From: Laurie Leader <LRL@portlandmaine.gov>
Sent: Thursday, July 31, 2014 11:20 AM
To: Steve Koeninger
Subject: RE: BP#2014-01486 106 Douglass Street - Plan review comments

I have reviewed the revisions sent back.

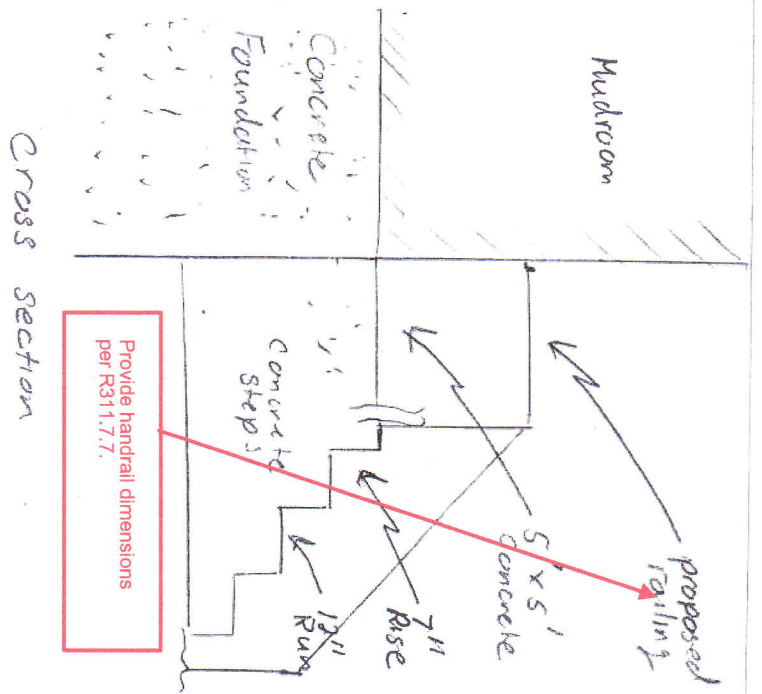
1. Can you please revise the handrail height per IRC 2009, handrail height shall not be less than 34" and not more than 38".
2. Provide header information for door going from the proposed mud room to the existing house. Provide framing detail where mud room attaches to the existing house.
3. Clarify if any foundation and framing work will be necessary where existing bulkhead is being removed and new bulkhead is being installed. It is not clear what is being done at the bulkhead other than the Bilco door installation.
4. Provide continuous footing under foundation wall per IRC 2009 Section R403.
